Case number ACP-324165-26

I am responding to the letter of 14 August 2026 from Honor Caird Marren

My response is confined to Section 4.3.2 (Nature Conservation) of the RtO

Figure A12-2-0.1. Noise Contours for Proposed Wind Farm and other wind farms

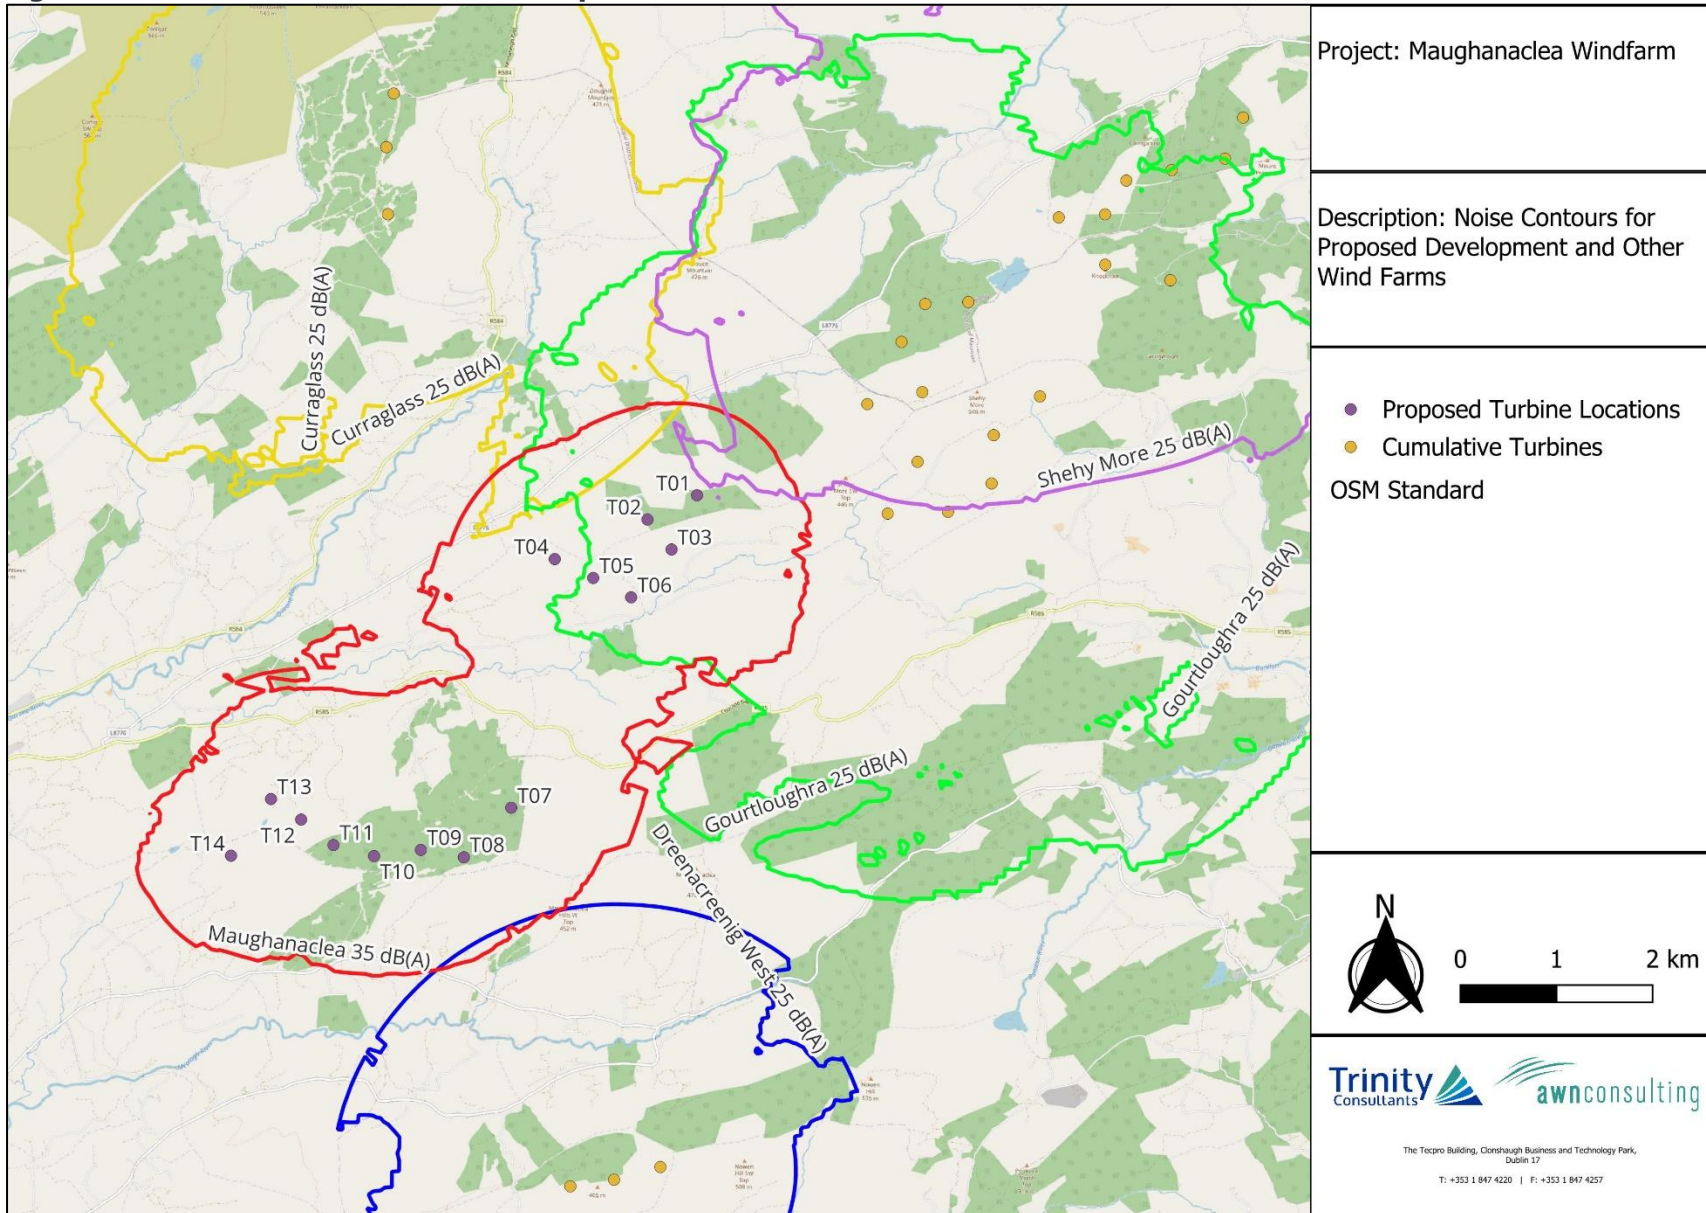
The applicant's RtO includes the Dreenacreenig West wind farm in its cumulative bird impact assessments. The original EIAR however did not include Dreenacreenig West in the cumulative assessments for landscape, visual impact, or noise. This means the applicant is using one set of neighbouring developments when assessing bird impacts and a different set when assessing everything else. I would suggest that this discrepancy needs explaining and addressing.

In my opinion An Coimisiún Pleanála should require the applicant to provide a consistent cumulative baseline, and also should require detailed nocturnal bird data based on best international practise.
